WEST SUSSEX COUNTY COUNCIL CONSULTATION

TO:	Arun District Council FAO: David Spring
FROM:	WSSC - Highways Authority
DATE:	3 March 2020
LOCATION:	Site 6 Chichester Road North Bersted
SUBJECT:	BE/19/20/DOC Approval of details reserved by condition imposed under ref BE/84/19/PL relating to Condition No 4 - Construction Environmental Management Plan.
RECOMMENDATION:	More Information

DRAWING TITLE
PHASE 4C - SITE SETUP PLAN

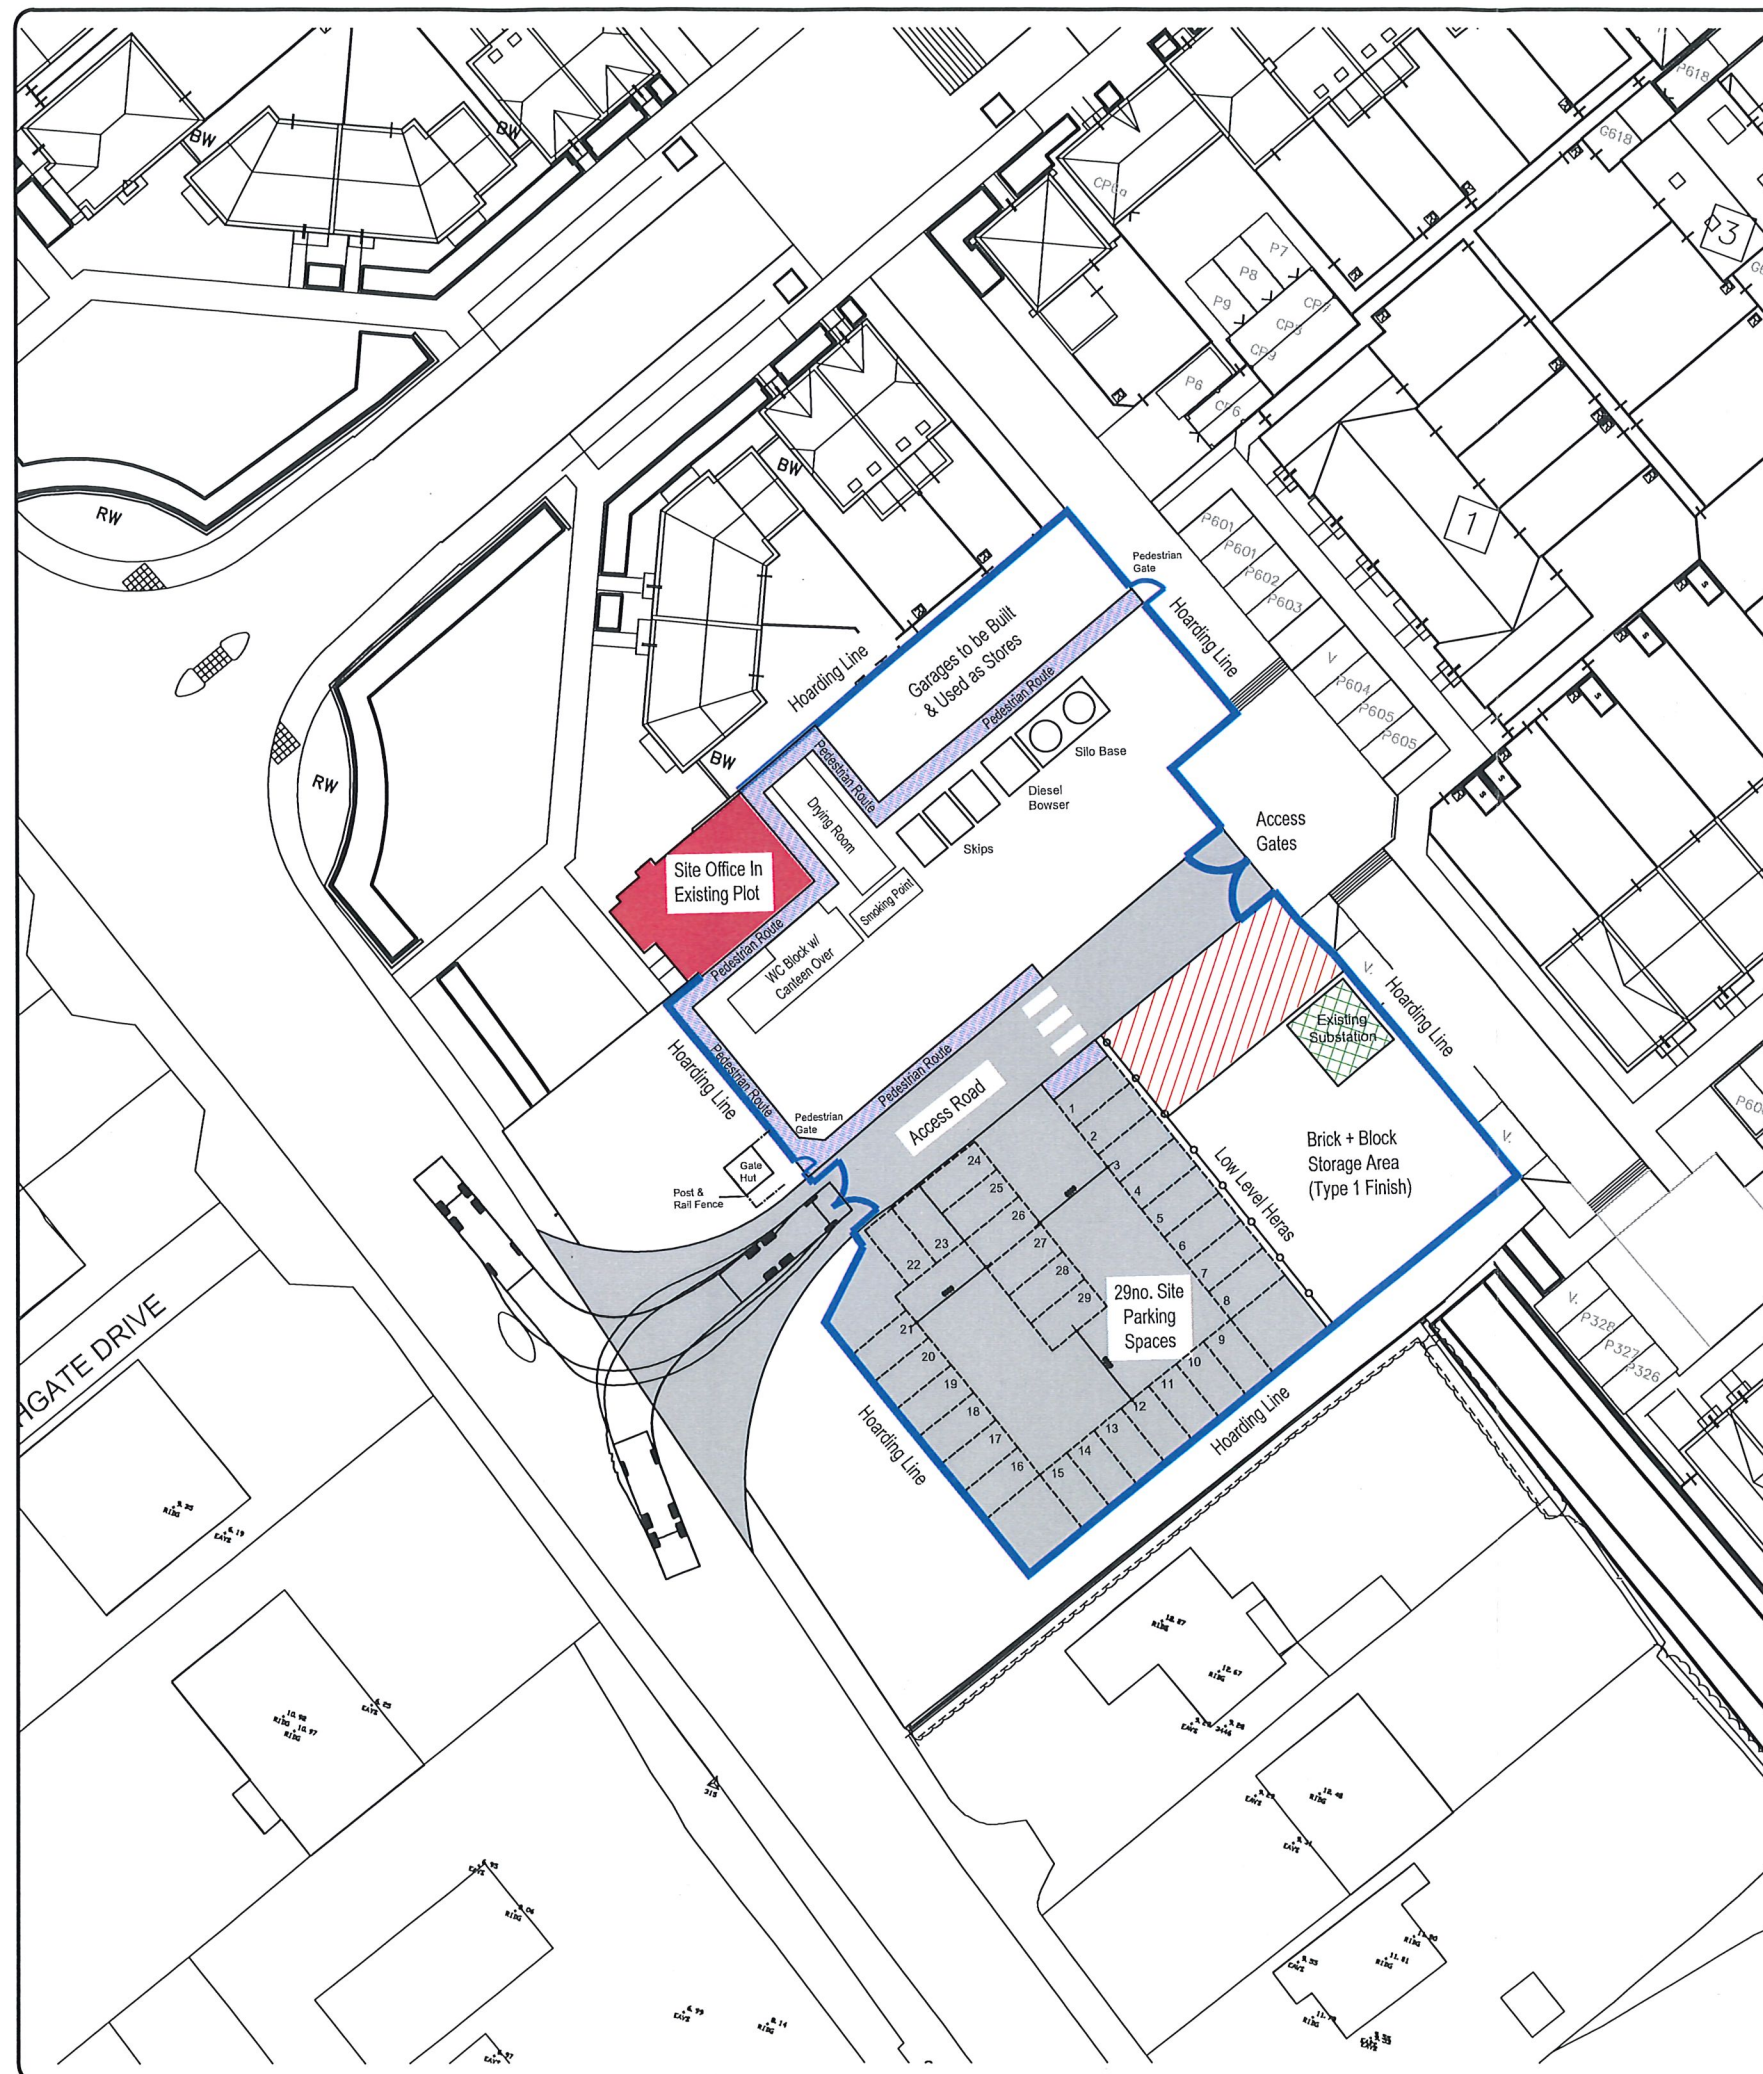
The matters LHA would assess in regards to construction phase would be clear demonstration of areas for parking of contractors, loading and unloading area including demonstration of turning on site, areas for storage of materials and to show location of wheel washing facility at site entrance/exit.

The CEMP does not make the above matters clear and whilst a plan has been provided the LHA cannot make out whether the above areas are marked on this.

Please ask applicant to provide further information in form of a detailed plan and re-consult.
